Rezoning Transportation Analysis

Petition Number: 2020-087

General Location Identifier: Tax ID 03904210

Date	Description
07-22-20	First Review

PLAINWOOD TOWNHOMES CHARLOTTE
 REZONING_PLAN R12MF

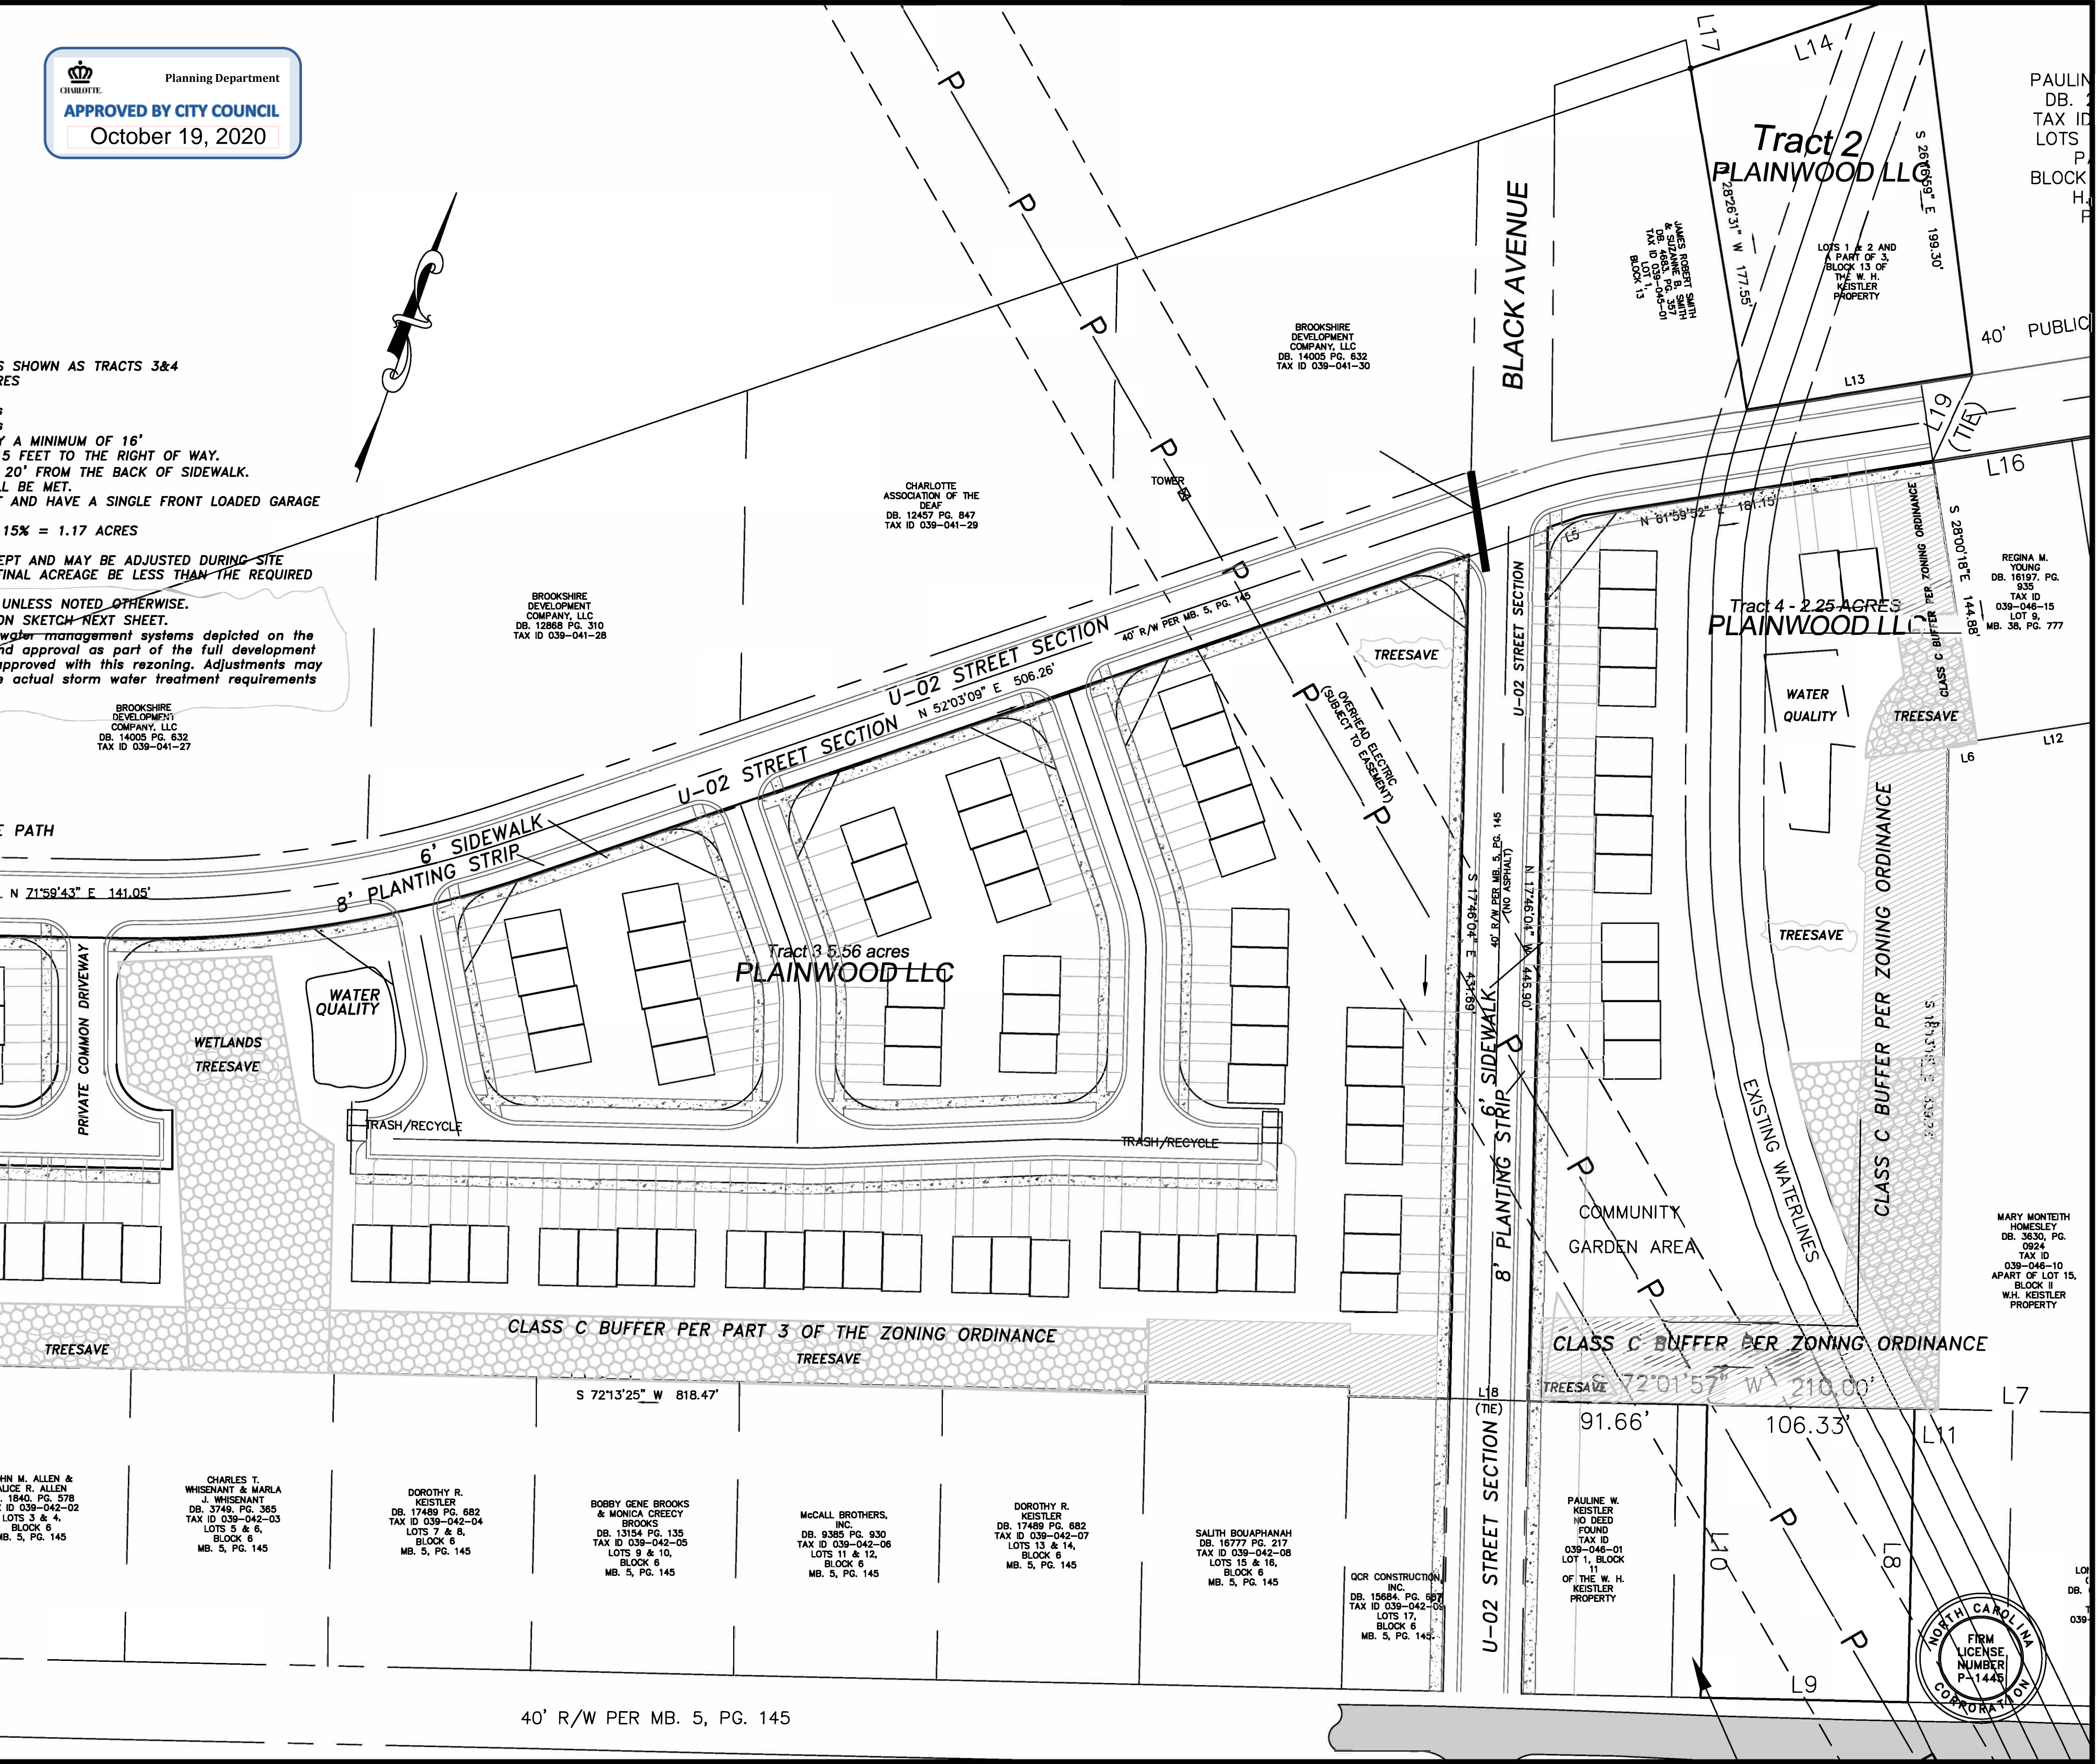
2. The petitioner should revise the site plan and conditional note(s) to commit to dedicate 50 feet of right-of-way from the road centerline of Brookshire Boulevard, which is classified as a major thoroughfare within the Comprehensive Transportation Plan. The site plan should label and dimension the right-of-way from the road centerline.

3. The petitioner should revise the site plan and conditional notes to revise all units fronting public streets to be alley-loaded.
4. The petitioner should revise the site plan and conditional note(s) to commit to construct an 8-foot planting strip, and 6-foot sidewalk on Plainwood Drive per Chapter 20 Subdivision ordinance. The site plan should label and dimension both items from the back of curb and gutter and road centerline.

5. The petitioner should revise the site plan and conditional note(s) to commit to construct bicycle facilities by installing a 12' multi-use path along Brookshire Boulevard to meet the City Charlotte BIKE Policy.

6. The petitioner should revise the site plan and conditional note(s) to construct a drop right-turn lane (northbound) on Brookshire Boulevard into Plainwood Avenue.

7. The petitioner should revise the site plan and conditional note(s) to revise all USDG - U-01 Local Residential Narrow internal public street sections to either USDG U-02 Local Residential Medium or U-03 Local Residential Wide sections.
